**Colorado's Power Pathway – Xcel Energy Responses to El Paso County Referral Comments**

COLORADO'S POWER PATHWAY

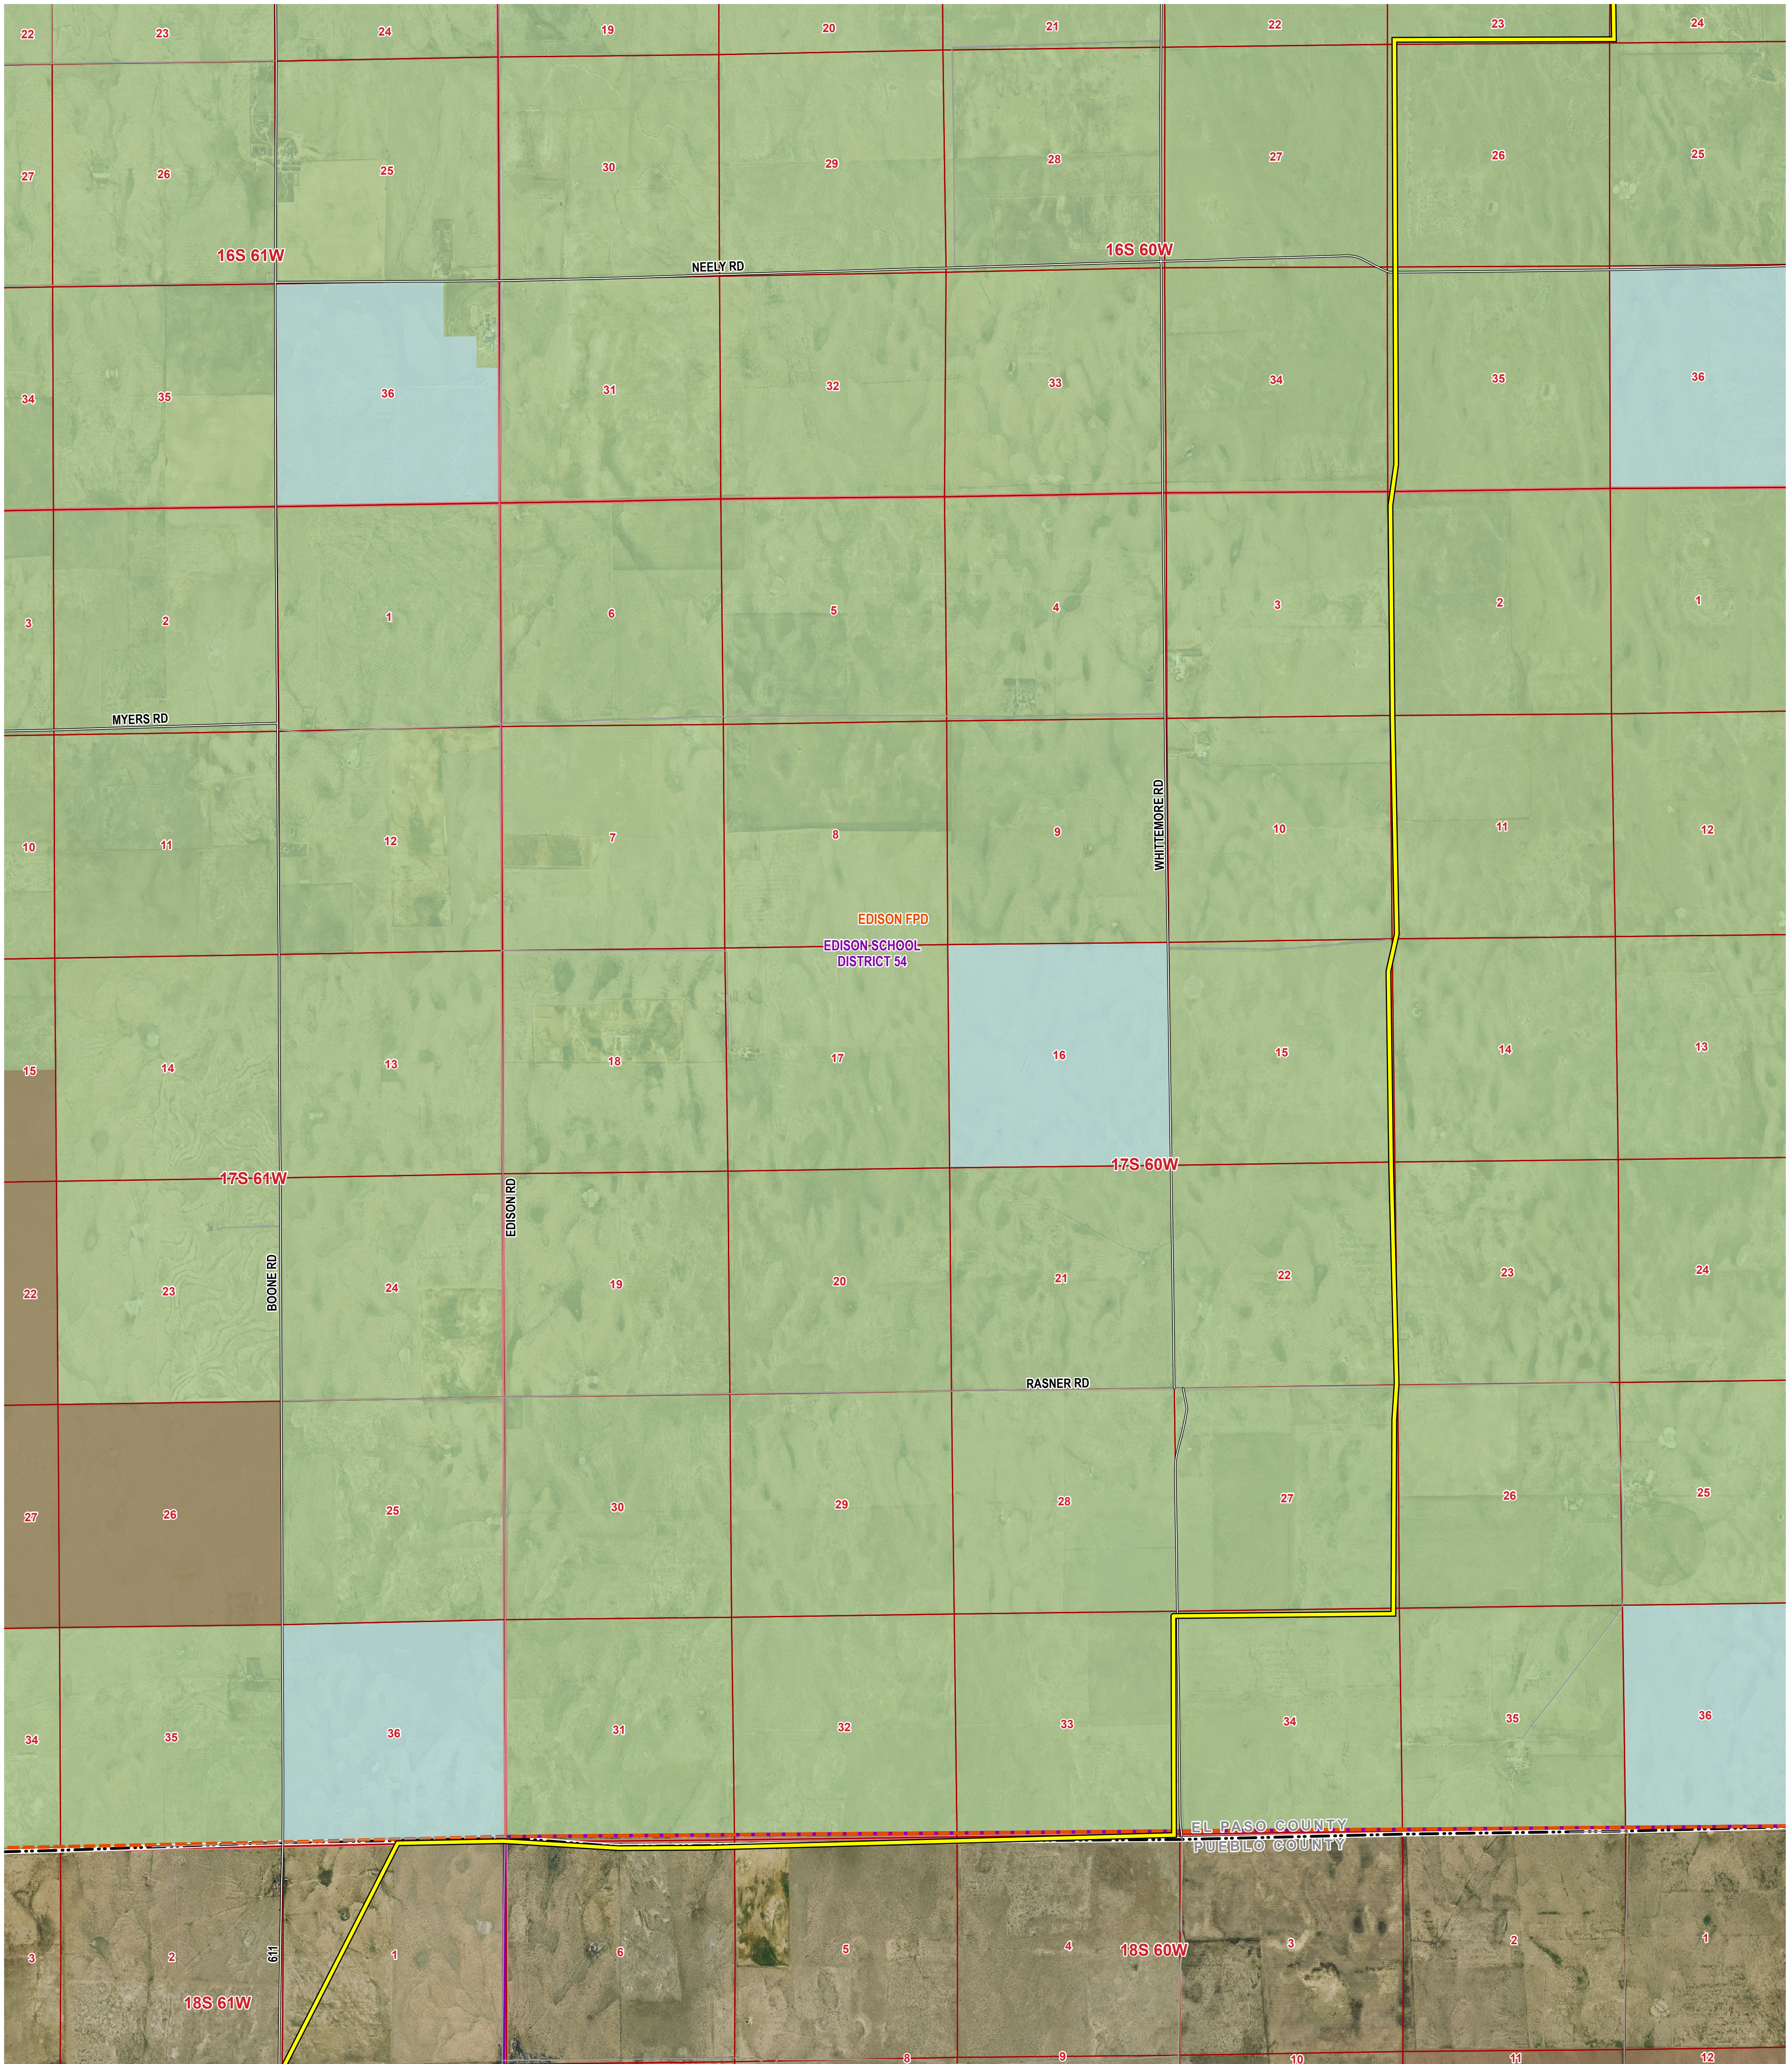
1. You have provided a zonemap- Please add a symbol or label of land use- is land adj to line vacant; has residence; commercial business- the land use is not identified in the exhibit.	The Land Use and Zoning Map has been revised to indicate adjacent land uses. The revised Land Use and Zoning Map is provided as Resubmitted Attachment F.
<b>PCD Project Manager_2024-08-19_Comment.txt</b>

1. Zoning and Land Use Map- No land-uses were shown.	The Land Use and Zoning Map has been revised to indicate land uses. The revised Land Use and Zoning Map is provided as Resubmitted Attachment F.
<b>PCD Project Manager_2024-08-19_003.pdf</b>	
Attachment I: Transportation Memorandum 1. See comments on Haul Route Plan and update accordingly	The Revised Transportation Memorandum has been updated to address comments received in the following documents: <ul style="list-style-type: none"> <li>• El Paso County PCD – Project Manager_2024-08-19_004</li> <li>• Colorado Department of Transportation - Pueblo Office_2024-07-18_Comment</li> </ul> The Revised Transportation Memorandum is provided as Resubmitted Attachment I.
<b>PCD Project Manager_2024-08-19_003_Comment.txt</b>	
Traffic impact Study Comments	The Revised Transportation Memorandum has been updated to address comments received in the following documents: <ul style="list-style-type: none"> <li>• El Paso County PCD – Project Manager_2024-08-19_004</li> <li>• Colorado Department of Transportation - Pueblo Office_2024-07-18_Comment</li> </ul>
